Brown Road Long Plat Conditions For Final Approval	COMPLETED	NOTES	STAFF REVIEW
Building			
<p>A. All new construction must meet the International Residential Code requirements.</p> <p>B. Environmental and statutory review may be required for all current and future development, construction, and improvements. The applicant and/or all future owners of any lot or lots within this subdivision are responsible for compliance with all applicable local, state, and federal rules, requirements, codes, and regulations. It is incumbent upon said applicants and future owners to investigate for, and obtain from the appropriate agency or their representative, all required permits, licenses, and approvals for any development, construction, and/or improvements that occur within the boundaries of this subdivision.</p>	Yes	Applicant will comply	
Roads and Transportation			
<p>A. This application is subject to the latest revision of the Kittitas County Road Standards. The following conditions apply and must be completed prior to final approval of this project. A performance guarantee may be used in lieu of the required improvements, per the conditions outlined. (KCC 12.01.150)</p> <p>B. A driveway sh

## BROWN ROAD SHORT PLAT PART OF SECTION 4, T. 17 N., R. 18 E., W.M. KITITAS COUNTY, WASHINGTON

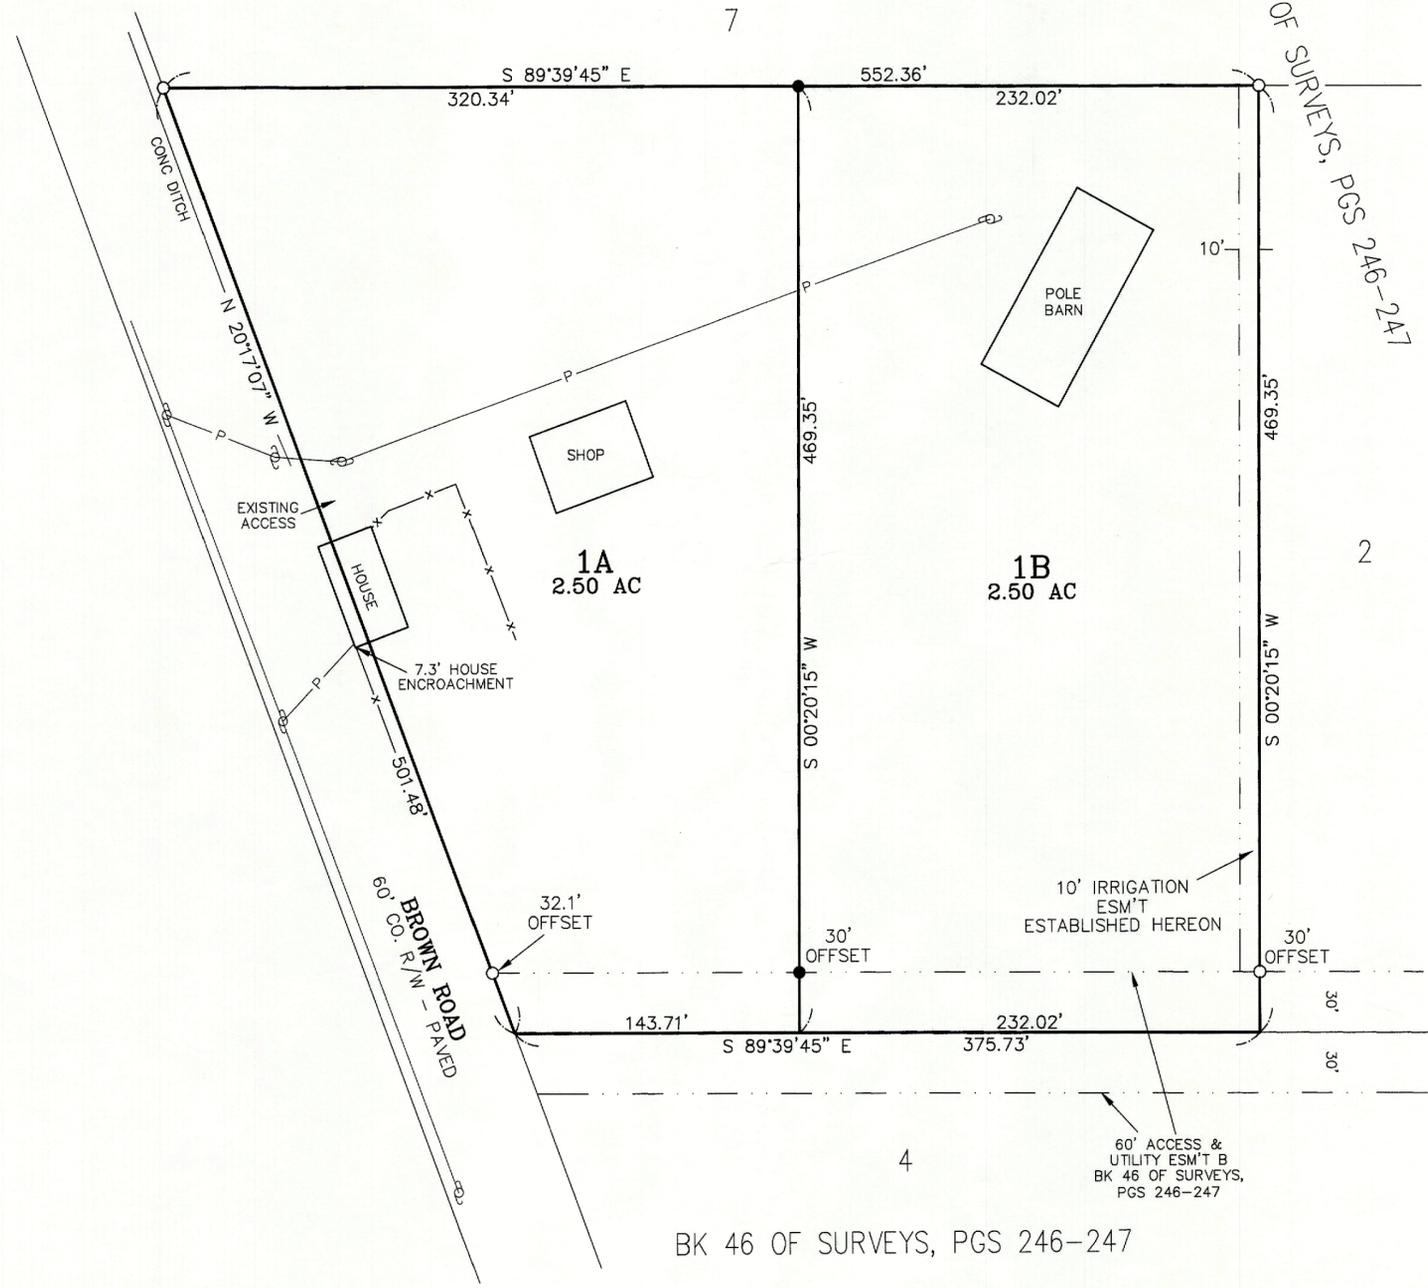
C. The following survey corrections/notes shall be reflected prior to final short plat approval:			
i. Survey shall meet WAC 332-130-145 topographic elements.	Yes	Applicant has compiled	
ii. Survey shall show encroachment distances of existing building(s) into Brown Road Right-of-Way.	Yes	Applicant has compiled	
iii. Shall show all structures on parcel, and/or provide a statement if structures have been demolished.	Yes	Applicant has compiled	
iv. Adjacent lots 2, 4, and 7 shall include reference to the recorded survey.	Yes	Applicant has compiled

v. The 60-foot access easement shall include reference to recording number of the creation documents.	Yes	Applicant has compiled	
D. Both sheets of the final mylars shall reflect short plat number SP-25-00009 and an accurate legal description shall be shown on the face of the final plat. Engineers and Surveyors need to be cognizant of all the requirements related to Final Plats (KCC 16.20) and Survey Data and Dedications (KCC 16.24). The final plat must be submitted in full conformance with these chapters of Kittitas County Code; non-compliant mylars will be rejected and returned to the applicant. A final plat file number will be assigned when CDS receives your final plat application. This file number will also be required on the face of the final plat.	Yes	Applicant has compiled
